CITY OF PORTLAND BUILDING PERMIT

Job ID: 2012-03-3601-FAFS
install new supervised fire alarm system

For installation at:
1707 CONGRESS ST

From: Benjamin Wallace
To: Michael Major
Date: 4/3/2012 10:06 AM
Subject: Re: 1711 Congress
CC: Michelle Perkins
Attachments: Benjamin Wallace.vcf

FIRST FLOOR FIRE ALARM PLAN
SCALE: 1/8"=1'-0"
FIELD VERIFY DIMENSIONS

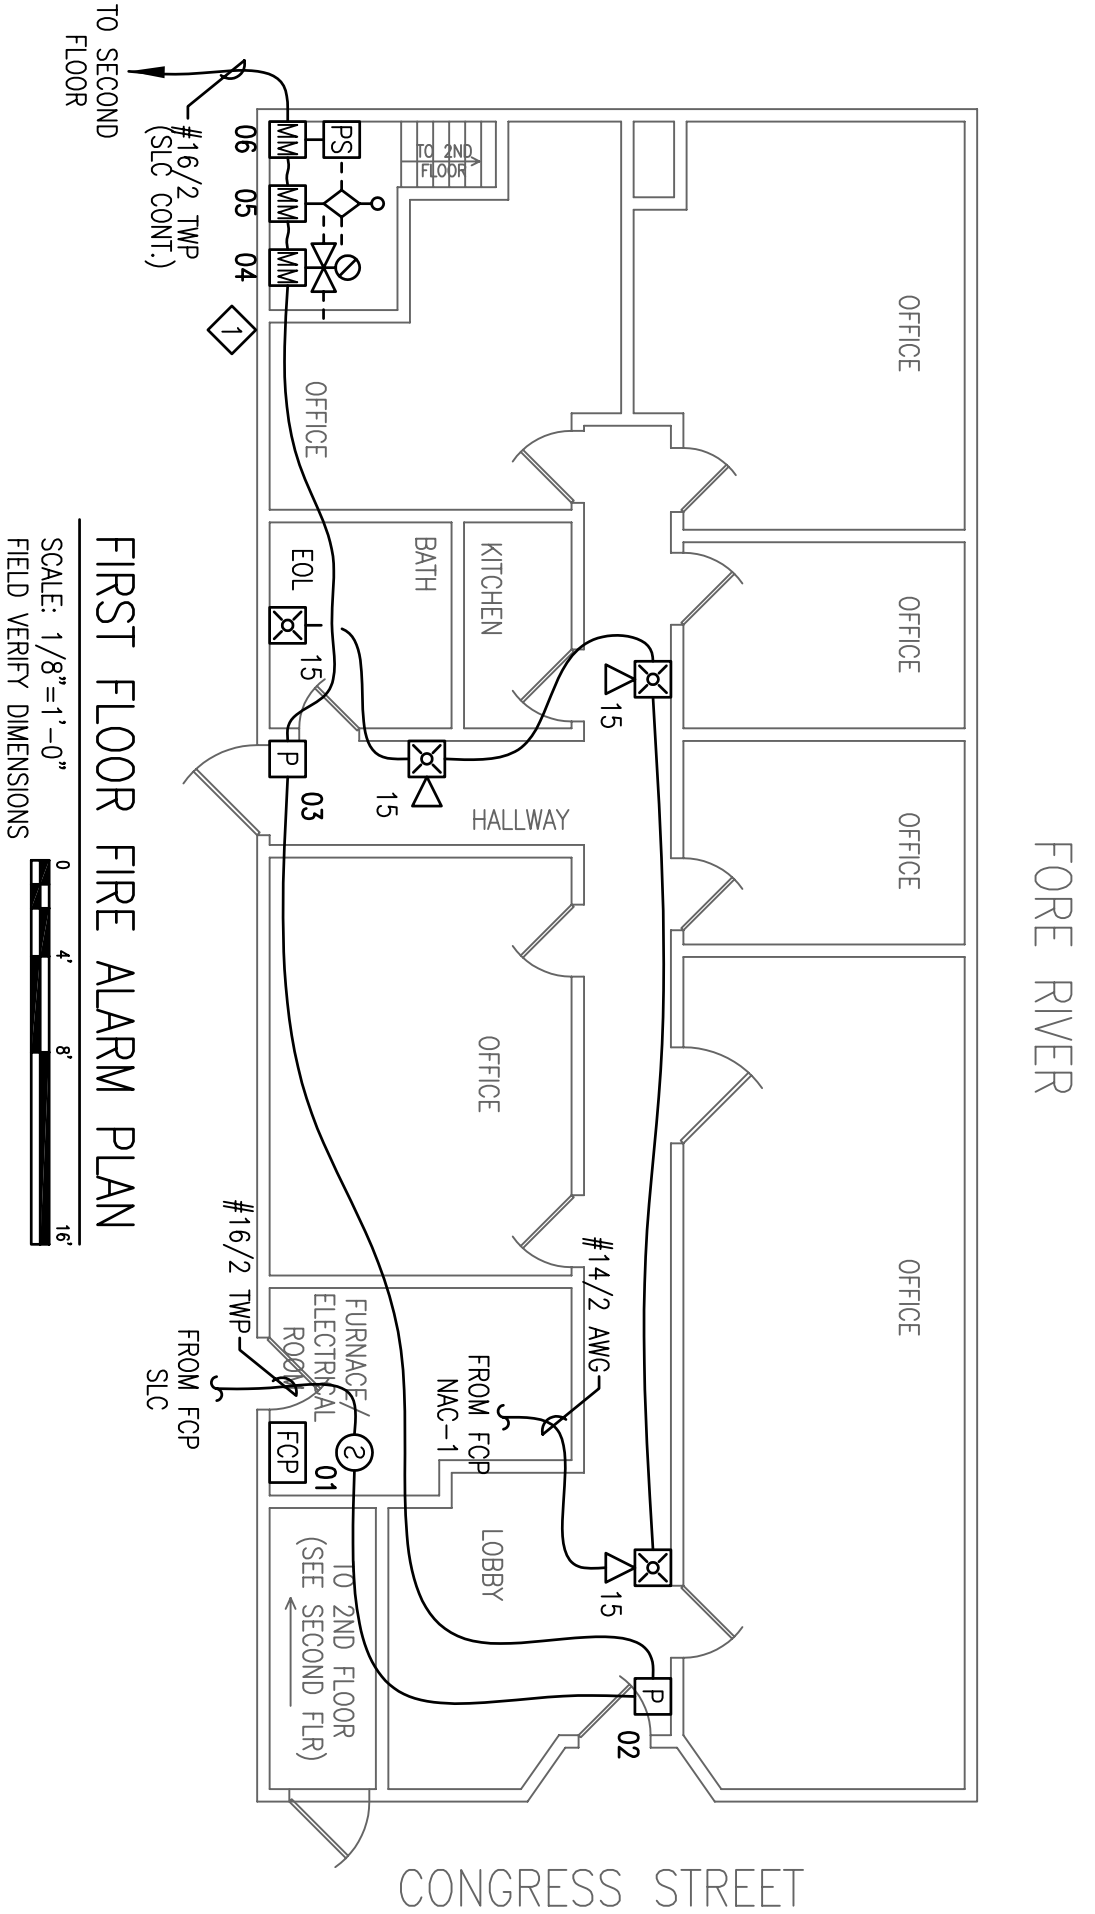
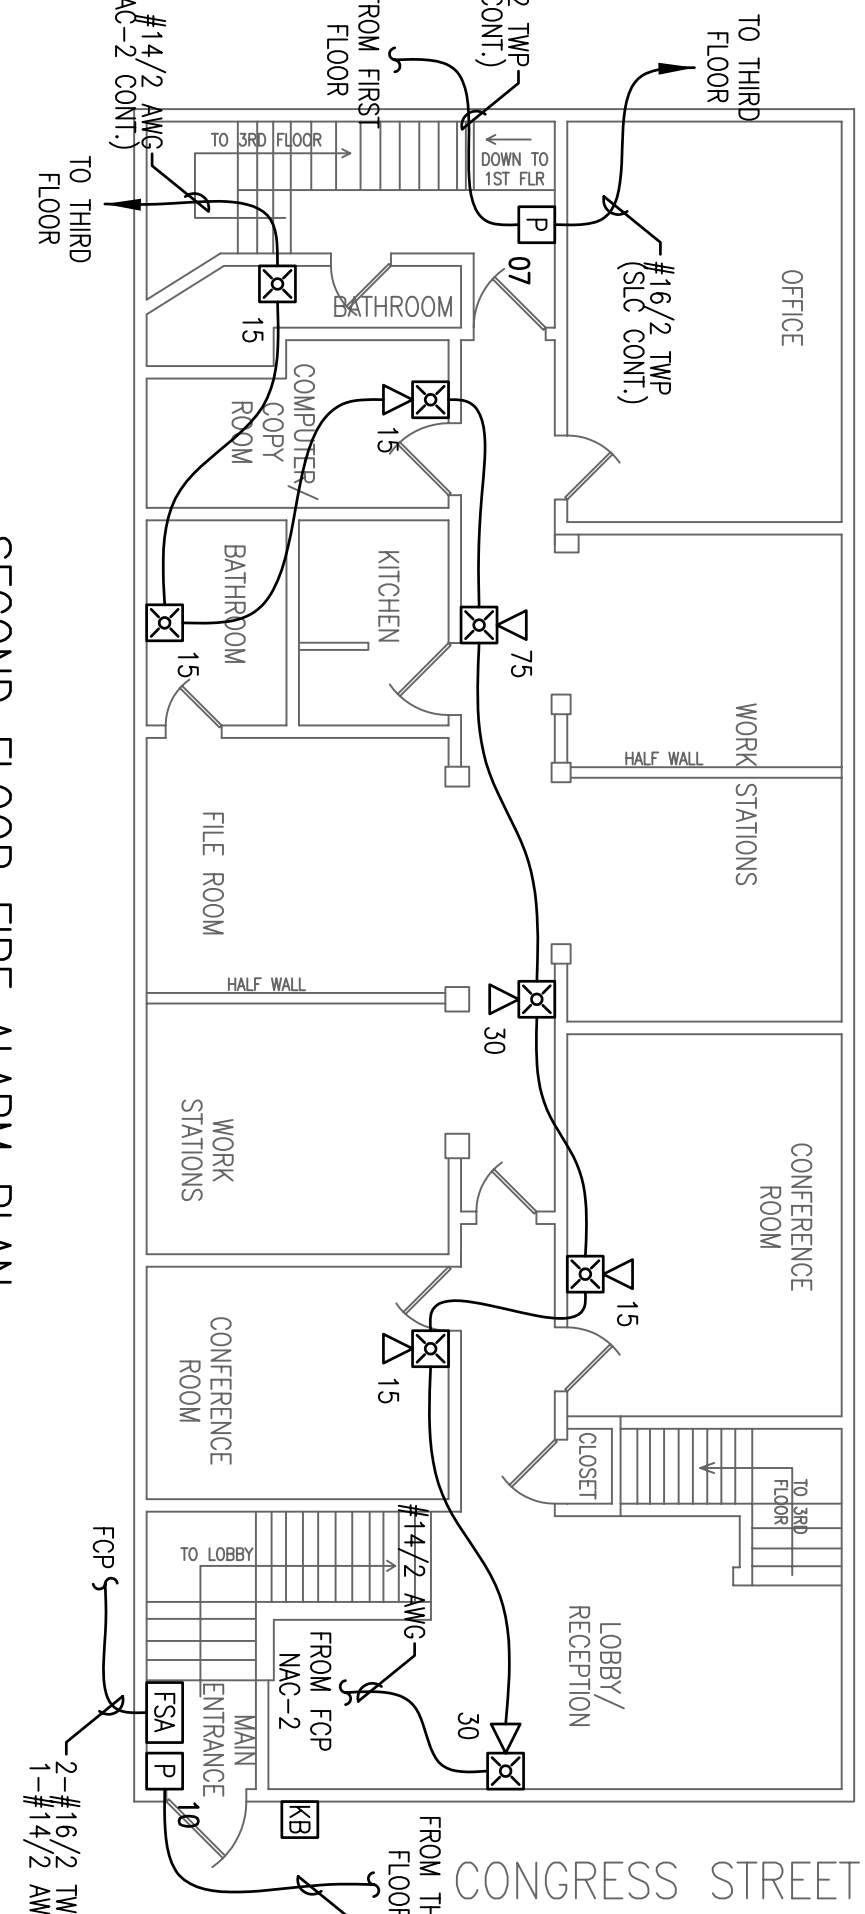
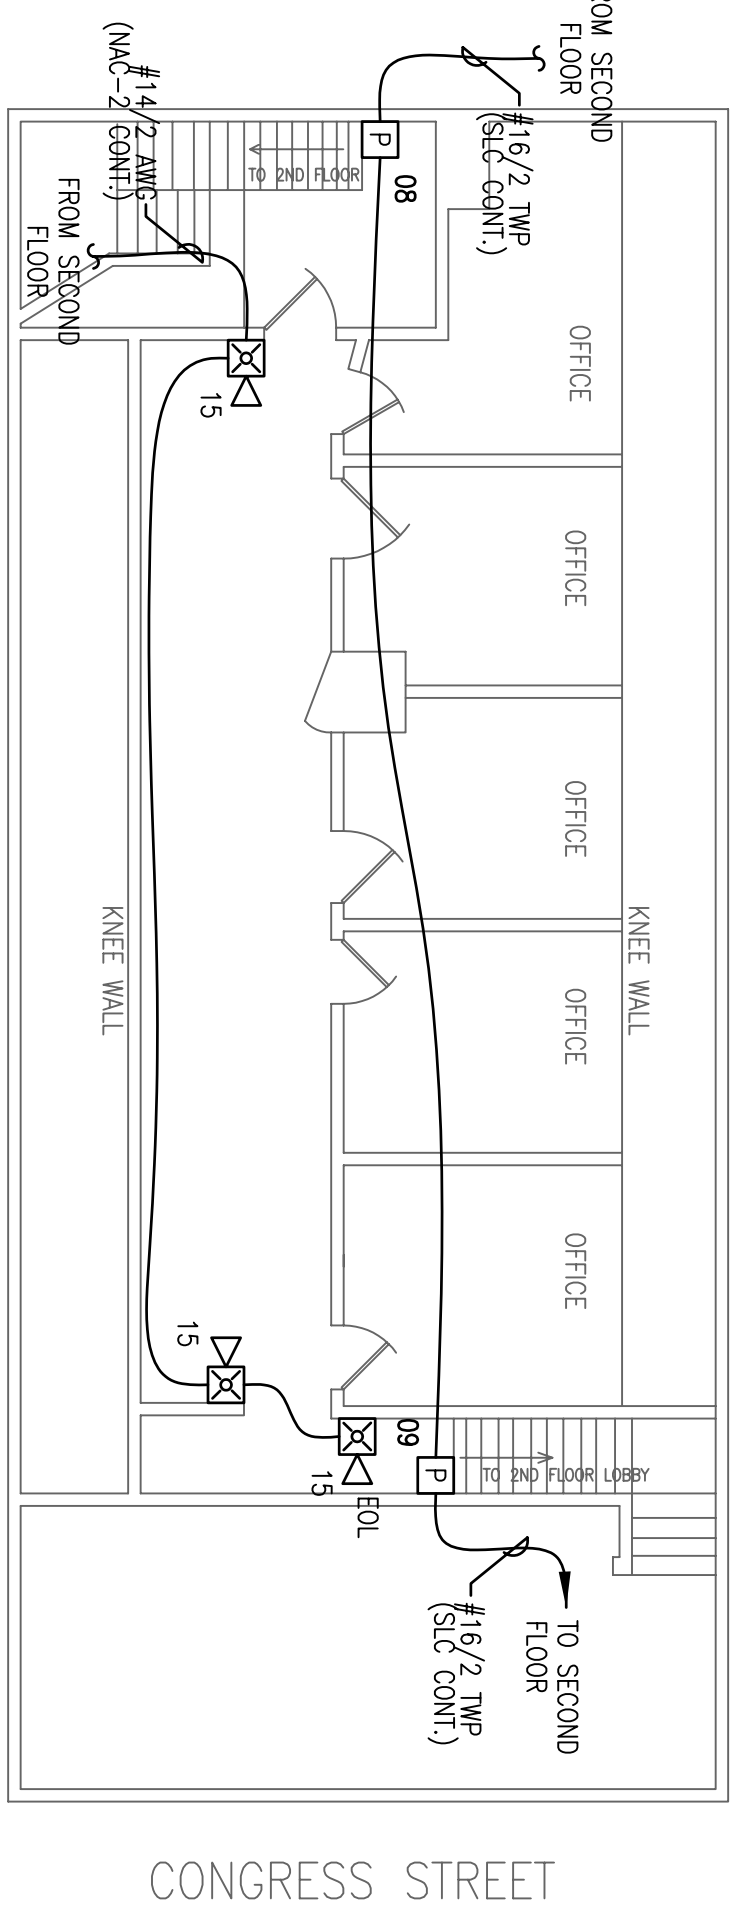
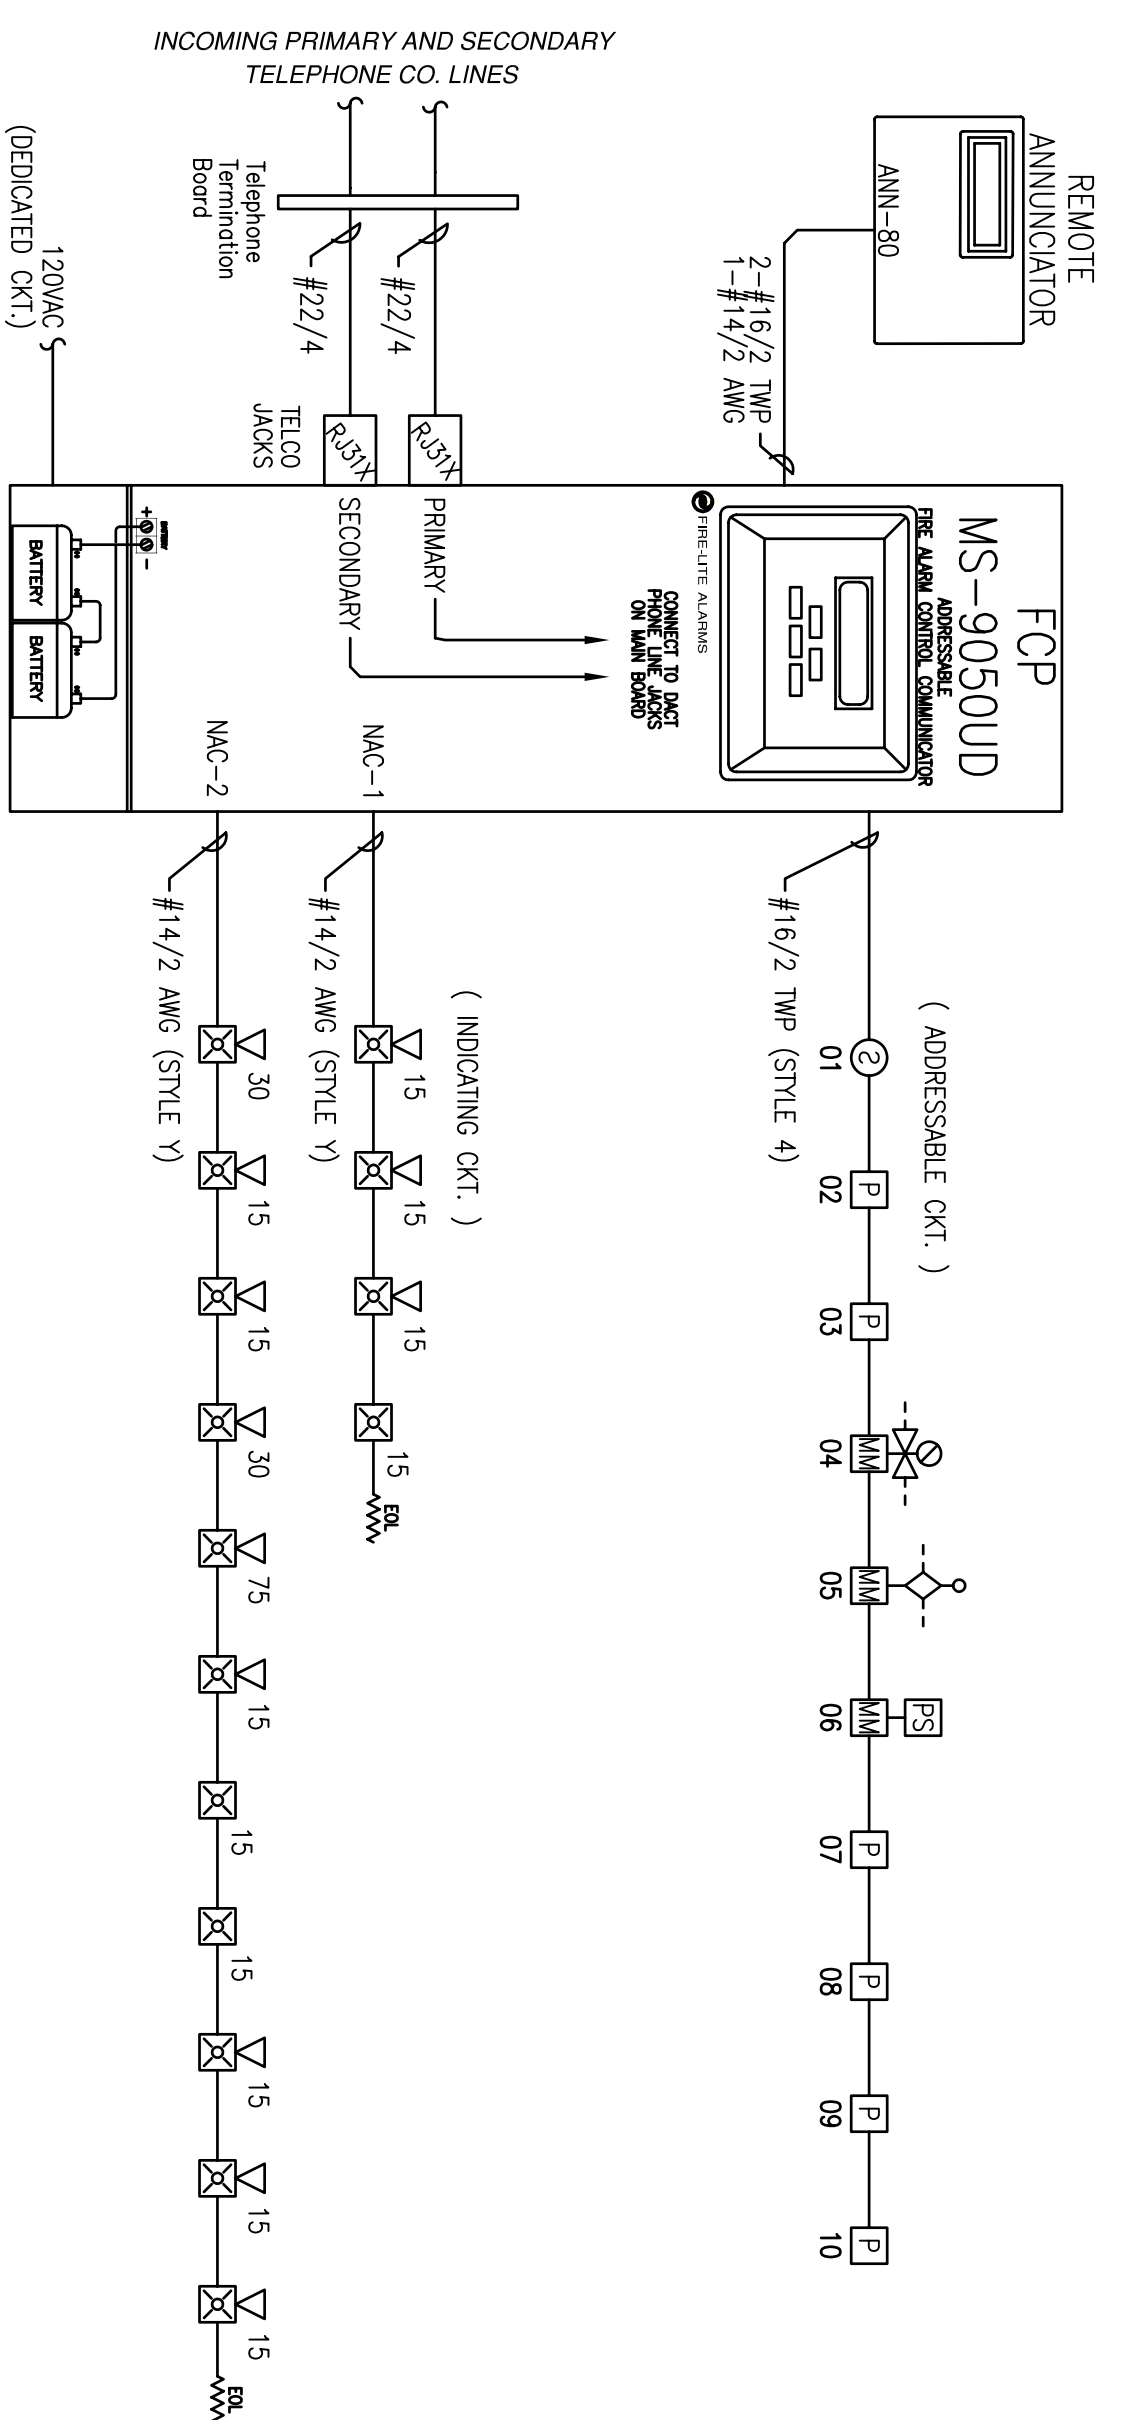
I think the discussion focused around not needing complete pull station coverage as they were going to have a supervised, automatic sprinkler system throughout the building.

I've just looked over the permit application and it meets and exceeds minimum requirements. I'll approve it as is with a note that the only required pull station will be the one at the annunciator. Once the install is done you can just put as-builds in the doc box.

Is the reason the annunciator is at the bottom of the second floor suite stair because it's the owner occupied suite?

If the supervised automatic sprinkler system provides protection throughout the building the only pull station that is required shall be located at the annunciator entrance. Other pull stations are optional.
